Our Reference: SYD17/00774 (A21269583)
DP&E Ref: SSD 8529

BUILDING C1, HICKSON ROAD, BARANGAROO SOUTH

Reference is made to your email correspondence dated 14 February 2018, responding to queries raised in Roads and Maritime's email dated 1 February 2018.

1 | Ground Floor Demolition Plan
1:300

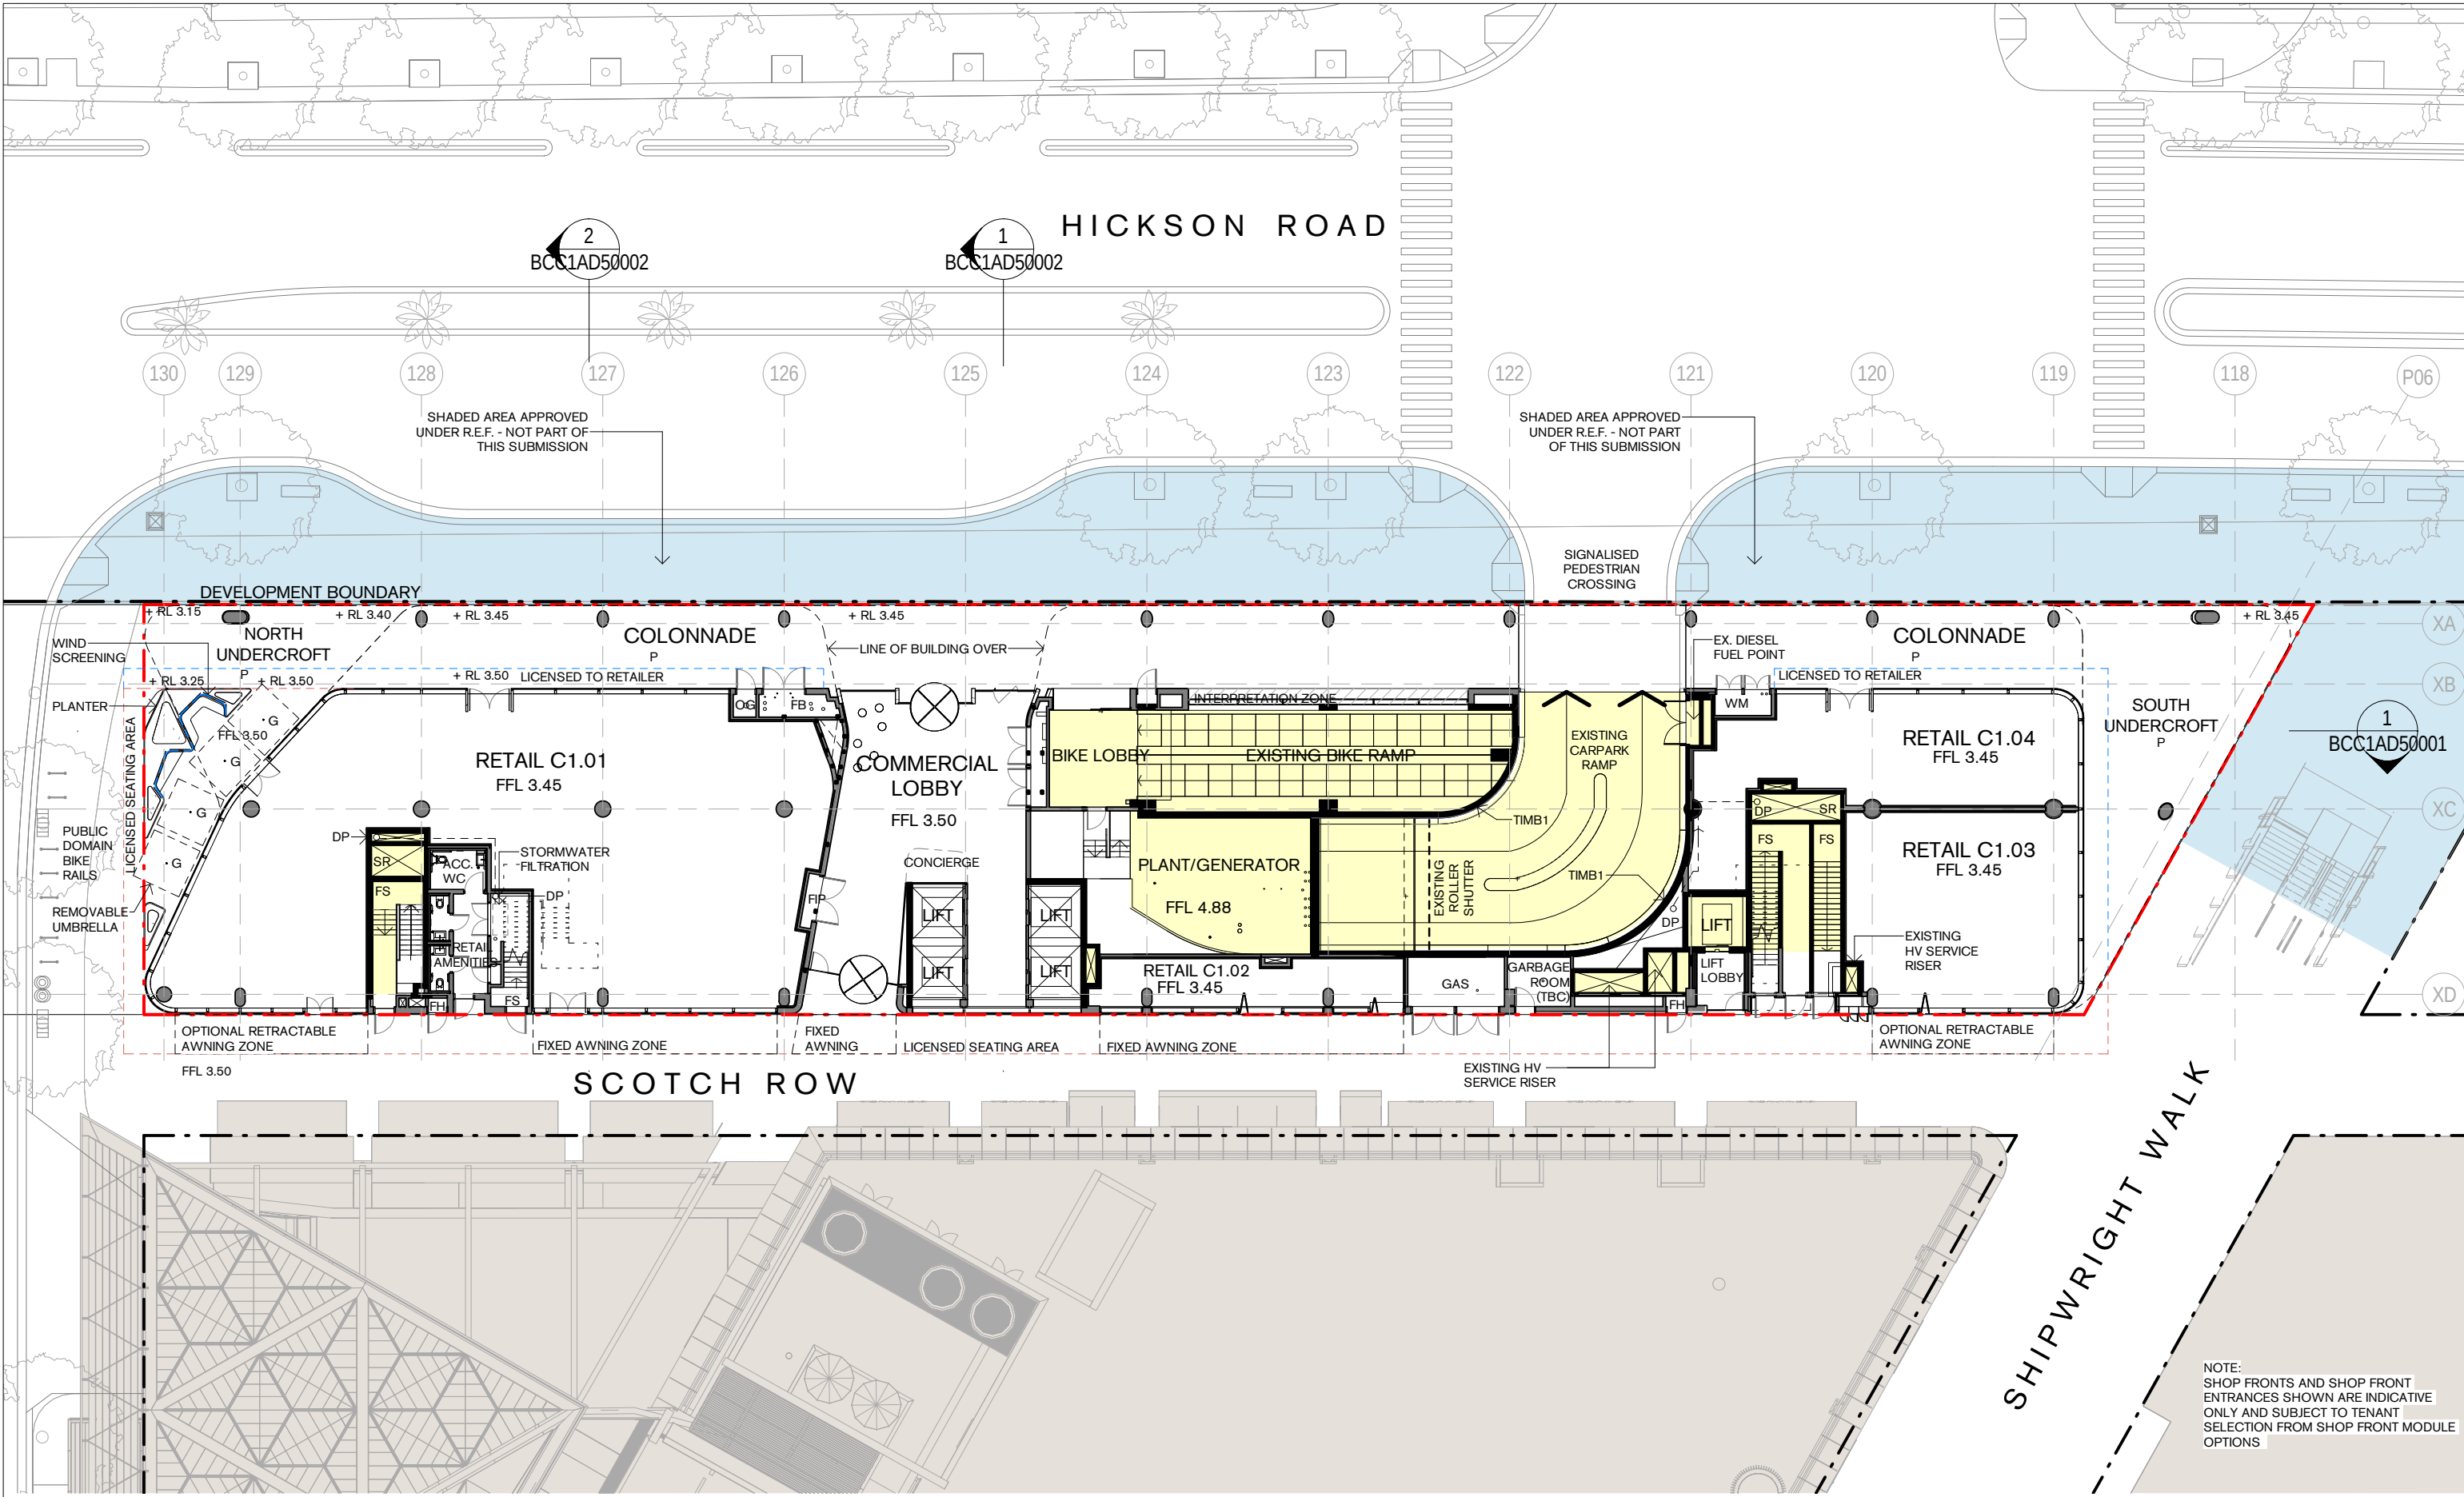
Roads and Maritime has reviewed the response provided and the proposed arrangements (as per mark-up TCS4625 Overlay 180213) would not be supported due to basic design issues (safety, etc) not being addressed. In particular, queries 2, 4, 5 and 6 do not appear to be fully addressed.

If the columns are at 500mm offset, then the stopping lanterns at the shown location would likely be blocked, even if the Traffic Control Signal (TCS) posts were at minimum 0.6m offset. Moving the columns to the north and the south should be considered.

The visibility of traffic signal displays are likely to be obscured, given the proposed location of the posts for the primary lanterns behind columns. The posts would also be in the middle of the crossings and may obscure sighting of pedestrians.

New TCS posts are to be provided at both ends of the crossing i.e. at the stop line so lanterns can be seen from the car park, and seen from the Napoleon Street stop line.

It is suggested that a TCS designer be consulted to prepare a suitable layout.

The above matters should be addressed in amended concept plans for further consideration by Roads and Maritime. Upon receipt of the amended plans, Roads and Maritime will provide a revised response accordingly.
